Ref: SPL-AF001

### **A303 Sparkford to Ilchester dualling order application**

In accordance with your letter of 21 July 2020 and Highways England's (HE) reply 17 August 2020 I am responding in summary form with comments I believe are important to be considered on whether or not to grant consent to the Development Consent Order (DCO).

FIGURE 2.5  
HAZLEGROVE JUNCTION UNDERBRIDGE  
GENERAL ARRANGEMENT

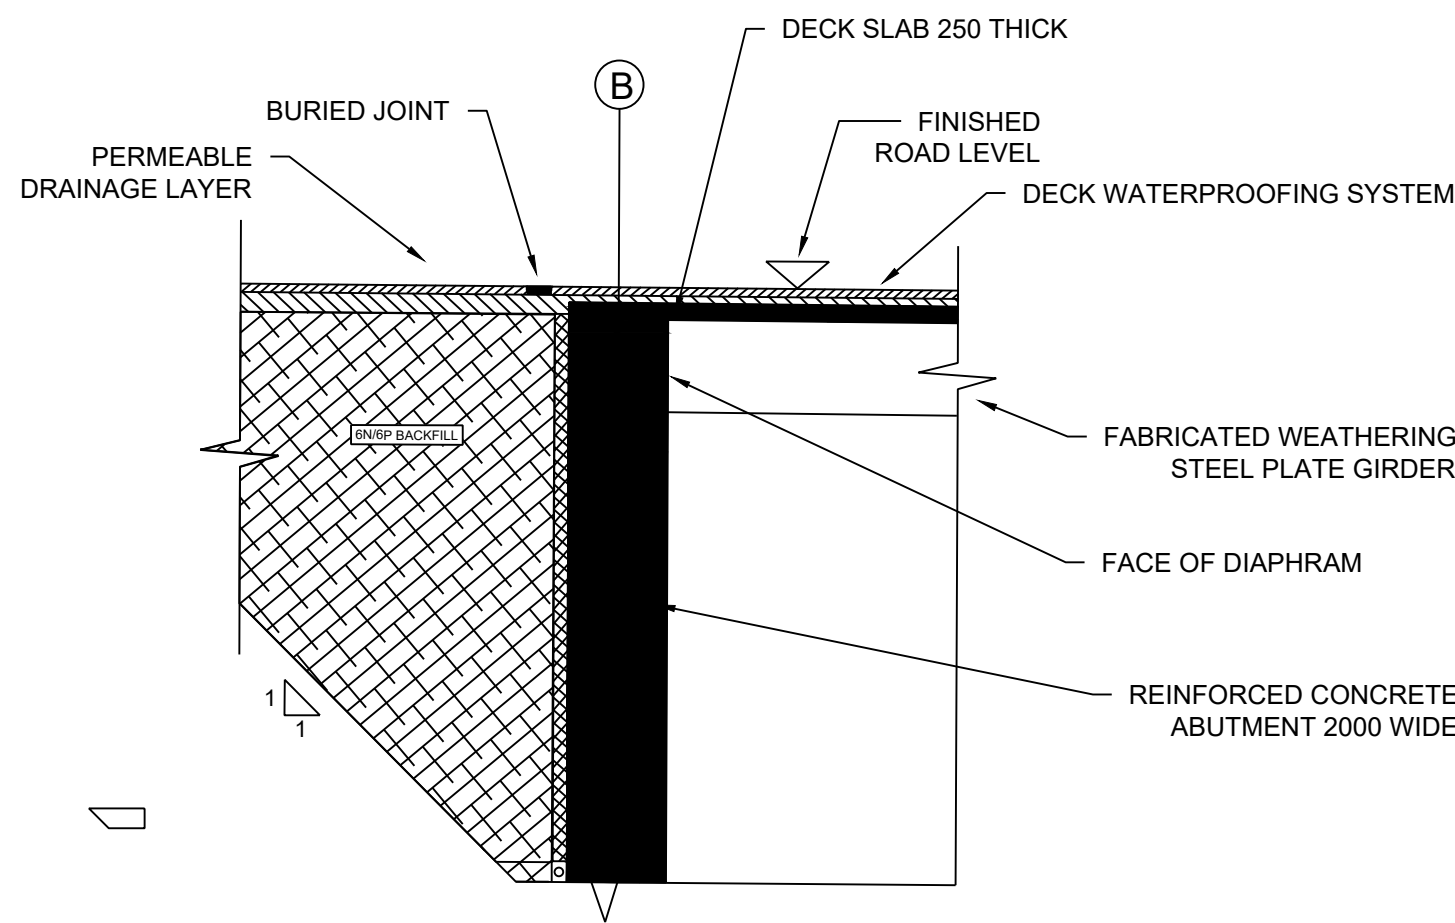
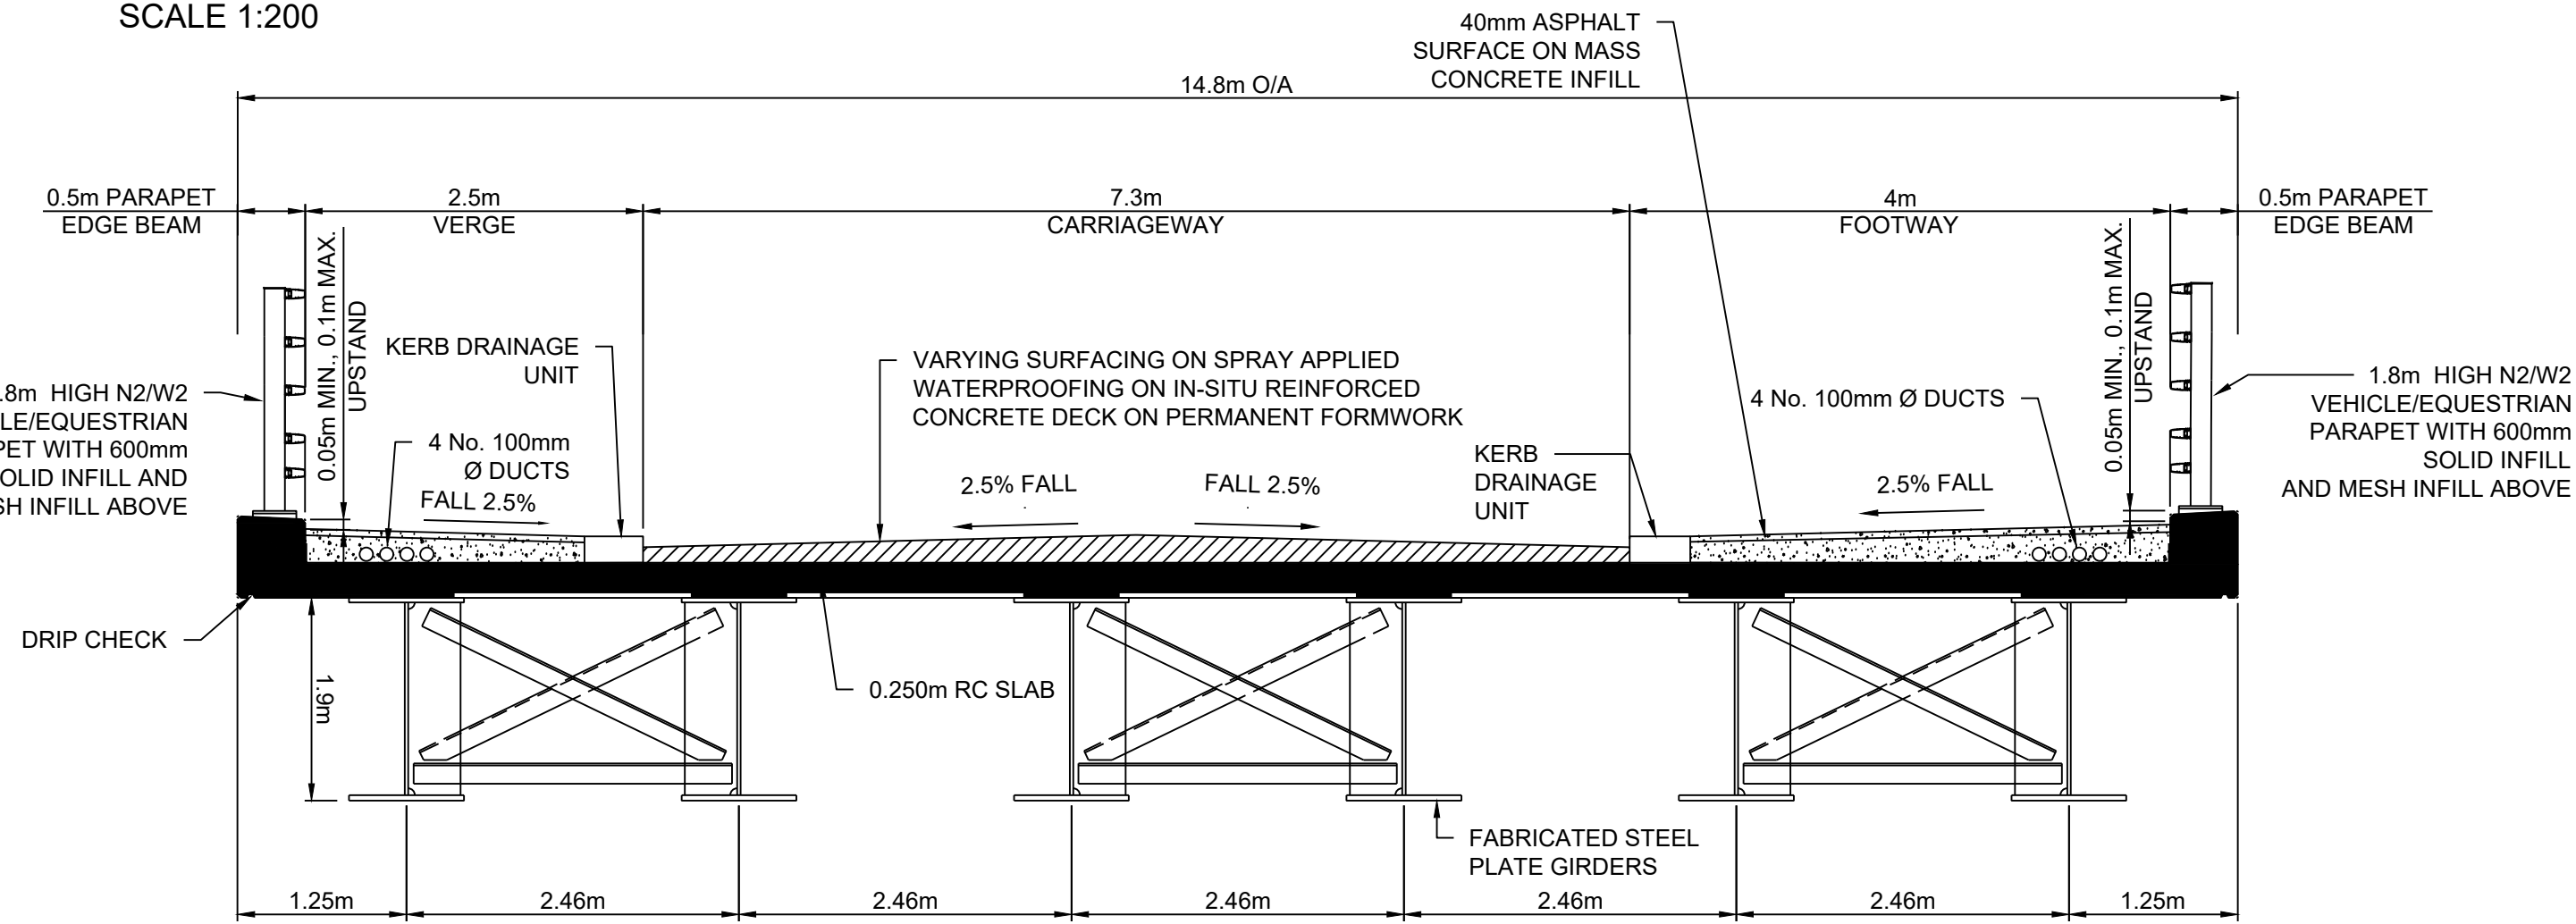
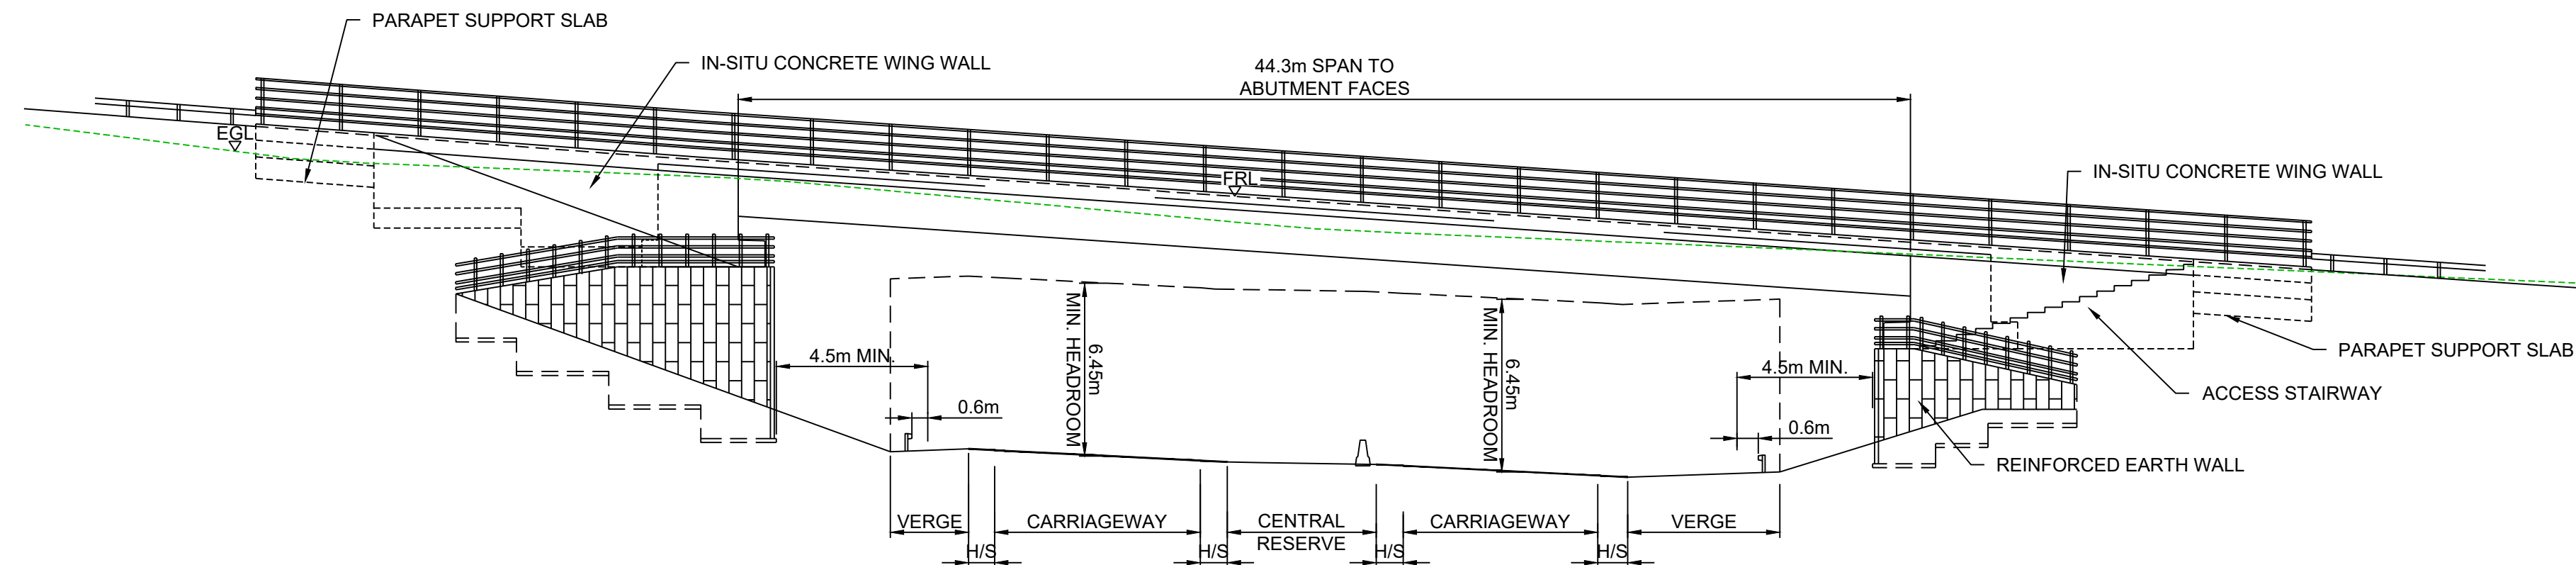
My only comment regarding the under bridge at the Hazlegrove junction is that I would not allow [REDACTED] to take their ponies through it, lit or not, and, having regard to the shortcomings of the Hazlegrove junction, the new design, if adopted, would provide an alternative safer route for NMUs, which also considerably shortens the distances for them compared to the present scheme.
